13 June 2024

**Outer Dowsing Offshore Wind (the trading name of GT R4 Limited) (“ODOW”)
Proposed Outer Dowsing Offshore Wind Farm Order (the “Project” and “the Order”)
Relevant Representation (Objection) on behalf of T.H. Clements & Son Limited (“T.H. Clements”)**

Environmental Statement
 Weston Marsh Initial Onshore
 Export Cable Corridor Options
 Figure 4.20

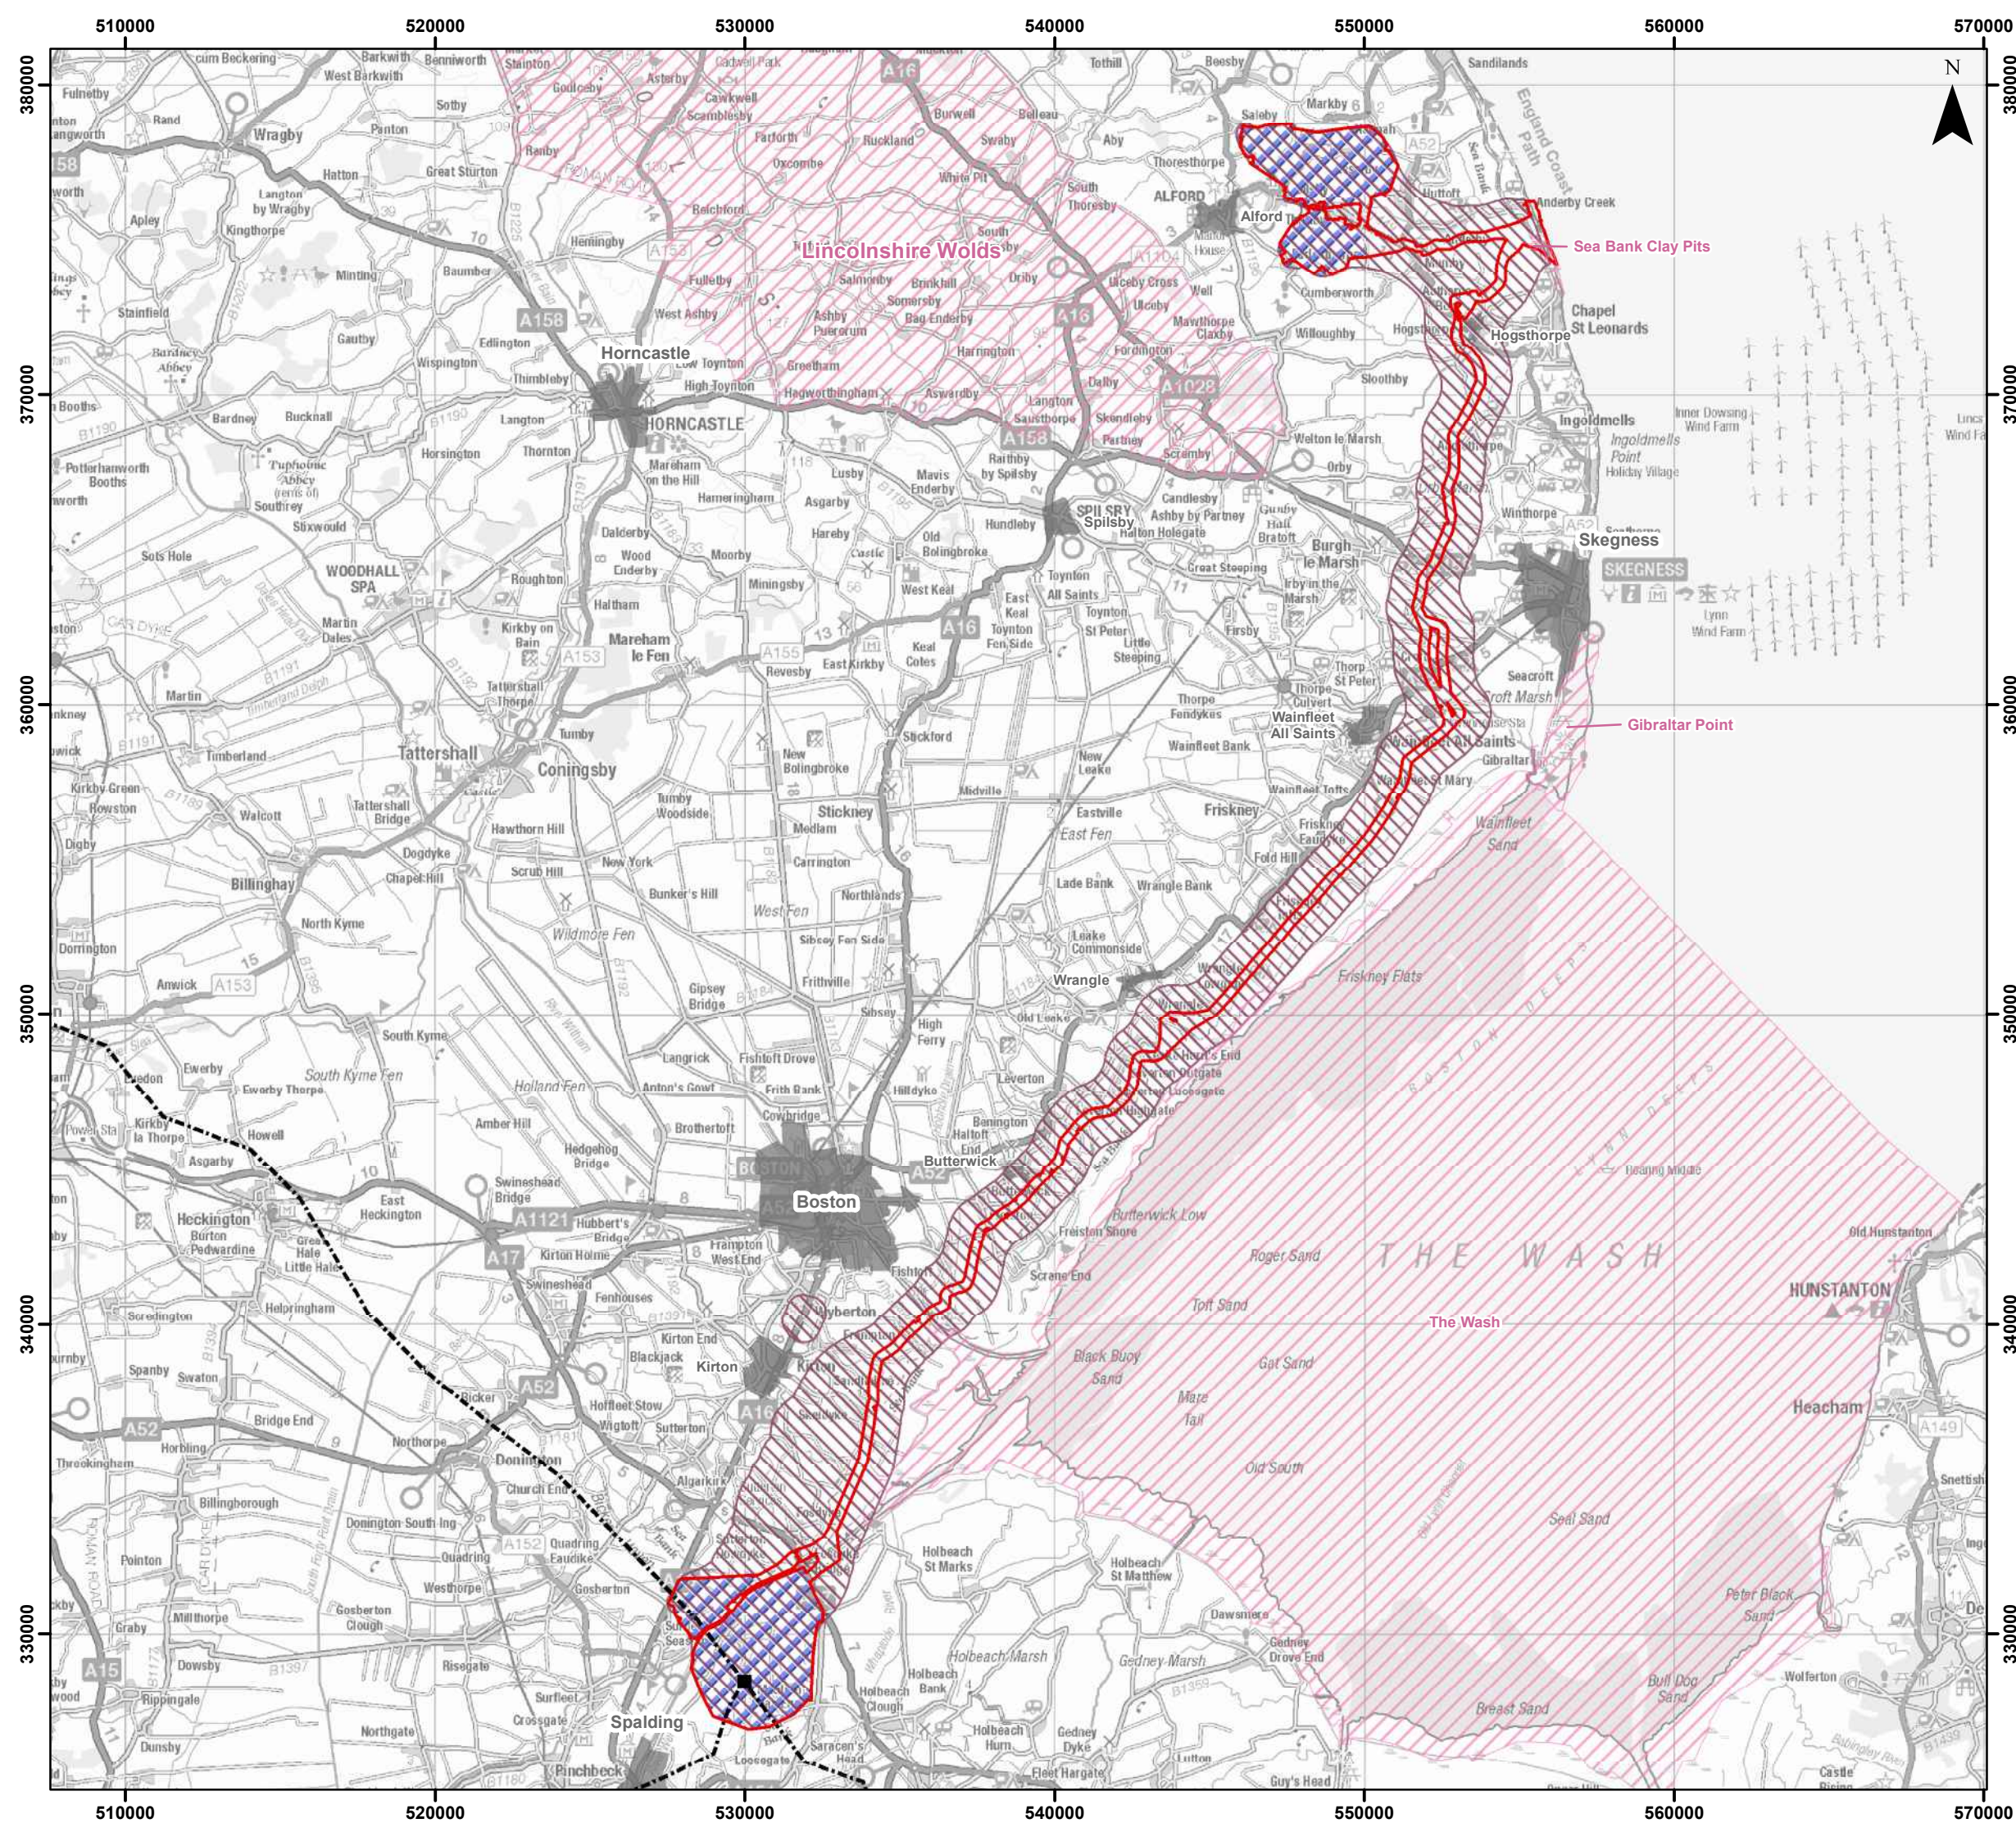
The first option ('Option 1', indicated by a blue line on Figure 4.20) originates at the landfall location at Wolla Bank, south of Anderby Creek, and follows a southerly direction, to the east of Burgh Le Marsh and Wainfleet All Saints, before crossing agricultural land to the south of the A52. The ECC then passes to the south of Boston, crossing the Haven, River Welland and A17. This appears to be the 'Wolla Bank-Weston Marsh' option in Table 4B.1 of Annex A.

The second option ('Option 2', indicated by a purple line on Figure 4.20) originates from the landfall point north of Anderby Creek and takes a more northerly direction to the northwest of Burgh Le Marsh. The ECC then runs parallel to the Boston to Friskney rail line before passing around the north of Boston, and circumnavigating the town in an anticlockwise direction. This option then joins the ECC of Option 1 to the north of Fosdyke. This appears to be the 'Boston Northern Option' in Table 4B.1 of Annex A.

The third option ('Option 3', indicated by a green line on Figure 4.20) follows the same route as Option 2 until it reaches Spilsby, at which point the ECC turns southeast to circumnavigate Boston in a clockwise direction. This option runs to the west of the Hobhole Drain before joining the ECC of Option 1 to the north of Fishtoft. This appears to be the 'Boston Southern Option' in Table 4B.1 of Annex A.

Table 4B.1 (in Annex A) is poorly laid out, which does not assist the reader, and the methodology employed is less than clear. The underlying analysis appears somewhat crude at best, detailing only the number of sensitive assets, or areas that have a sensitivity, without considering what the impacts would be and how serious they might be.

- Flood Risk Zones 2 and 3 are considered together, without taking into account whether or not the cable infrastructure is inappropriate development in such areas.
- There is no weighting at all so that, as regards water resources and flood risk, for example, impacting 1108.6ha of flood zone 2 and 3 is measured the same (i.e. all are rank 2) as impacting 1.3km of river and impacting 19.1ha of waterbodies for Option 2/the purple route.
- It is not clear what is meant by/or what the suggested impacts would be on railways where it is said that 11.0 and 11.1 km of rail is affected by the Purple

Route/Option 2 and the Green Route/Option 3 respectively (as depicted on Figure 4.20) and, further, why the 0.1km difference is sufficient to result in different rankings.

There is no assessment of actual impacts, it is all entirely comparative, so that the best of three objectively unacceptable route options would still come first. In short, the crude nature of the analysis inherently casts doubt as to whether the document shows with any certainty why the selected route (Option 1) is to be preferred.

Of particular note and concern to T.H. Clements, is the fact that ODOW make no distinction in their analysis between different grades of Best and Most Versatile land (“BMV”); the different grades are equally weighted. As such, ODOW’s analysis does not properly reflect the likely impacts on agriculture and BMV.

Choosing Option 2 (the purple route) would significantly reduce the amount of Grade 1 ALC land affected by the Project, and the majority of the Grade 1 ALC land that would be affected by this alternative route does not comprise the very top-quality silty soils situated to the east of the A52 public highway.

While Option 2 is slightly longer than Option 1, it would affect less Grade 1 ALC land, result in significantly less crop loss, and in doing so would ensure that the highest quality, productive farmland and associated businesses is/are properly protected from adverse impacts (please see below for further detail regarding adverse impacts on soils and, in particular, silts).
